**Response to Planning application from Hertfordshire County Council (T and CP GDP Order 2015)**

District ref: 6/2022/1610/HOUSE  
HCC ref: WH/13471/2022  
HCC received: 18 August 2022  
Area manager: Matthew Armstrong  
Case officer: Steven Knight

53 HIGH ROAD HATFIELD AL9 6HS

Extension of dropped kerb

53 High Road Dropped Kerb Extension

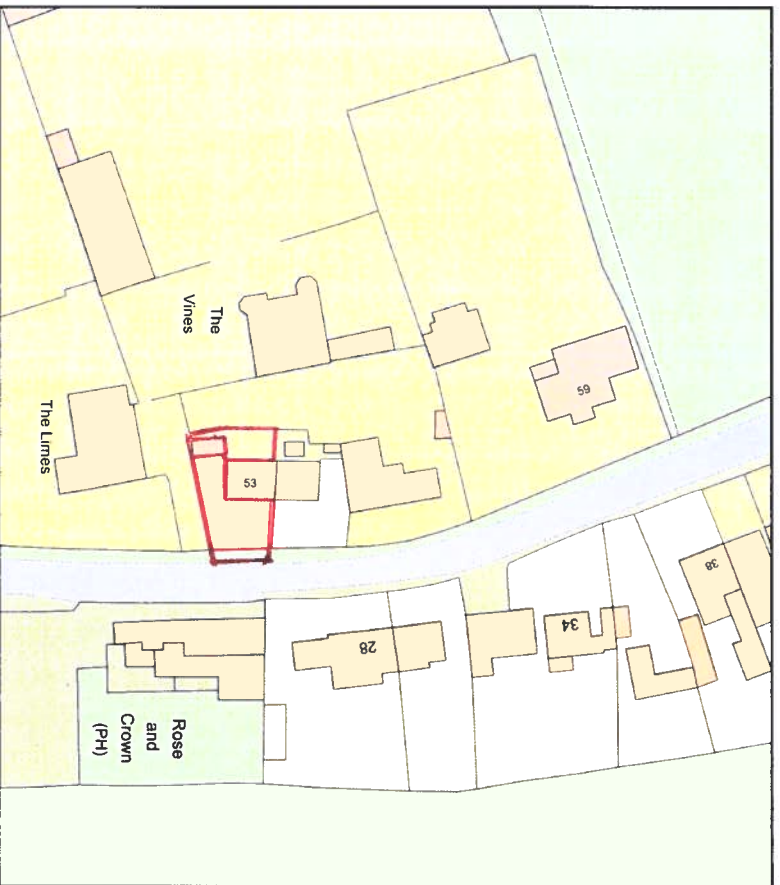
The existing dropped kerb was an extension a dropped kerb that serves several properties to the rear. The section of dropped kerb that extends in front of No.53 already consists of four flat kerbs (3.6m). HCC's dropped kerb terms and conditions states:

Based on this policy, the highway authority would not support the proposed extension.

The application does not provide a reason for the proposed extension. The drawing provided by the applicant shows that the driveway can already accommodate two vehicles and is not evident that a wider dropped kerb would make it possible to accommodate a third vehicle. Furthermore, it should be noted that vehicles should not reverse onto a classified road and should be able to turn around on the driveway and leave in a forward gear. It's questionable whether this is possible given the existing parking arrangement for two cars, but it is certainly considered that a wider dropped kerb is likely to encourage drivers to reverse into the road.
